Item No.	Report of the Head of Development Management and Building Control	
Address:	1 HURSTFIELD CRESCENT HAYES	
Development:	Change of use from a 6-bedroom small House in Multiple Occupation (HMO) (Use Class C4) to a 7-bedroom HMO (Use Class Sui Generis) for up to 7 people, including new cycle store (part-retrospective)	
LBH Ref Nos:	61118/APP/2024/595

The application seeks planning permission for the change of use from a six-bedroom small House in Multiple Occupation (HMO) (Use Class C4) to a seven-bedroom HMO (Use Class Sui Generis) for up to seven people, including a new cycle store (part-retrospective). Whilst no objection is raised to the change of use from Use Class C4 to a seven-bed sui generis HMO, officers consider that the submitted plans would result in a development that is tantamount to the subdivision of the property into a six-bedroom HMO with one substandard one-bedroom self-contained flat in the loft space. The proposal, as submitted, does not include satisfactory supporting information in relation to the need for additional parking and amenity space and issues relating to the impact on the existing and adjoining dwellings. The proposal is, therefore, contrary t

Figure 2 – Proposed second floor plans

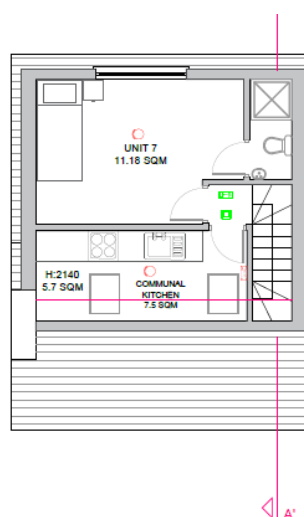
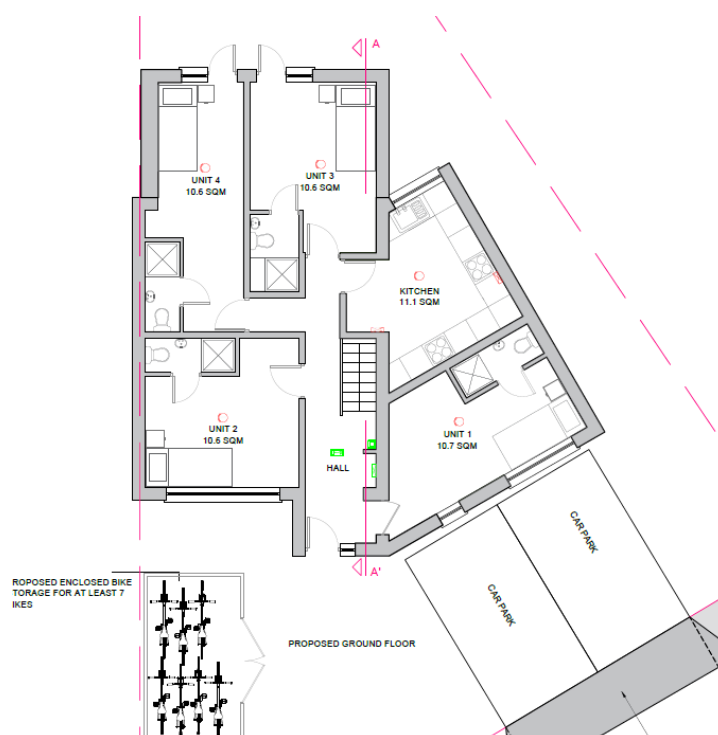
Following a site visit, Officers consider that the proposal is tantamount to the subdivision of the property into a six-bedroom HMO with a one-bedroom self-contained flat within the loft space. The internal floor area of the second floor amounts to 22m².

Officers consider, therefore, that the proposal is tantamount to the subdivision of the property into a six-bedroom HMO with a substandard one-bedroom self-contained flat within the loft space. The proposal, as submitted, does not include satisfactory supporting information concerning the need for additional parking and amenity space and issues relating to the impact on the existing and adjoining dwellings.
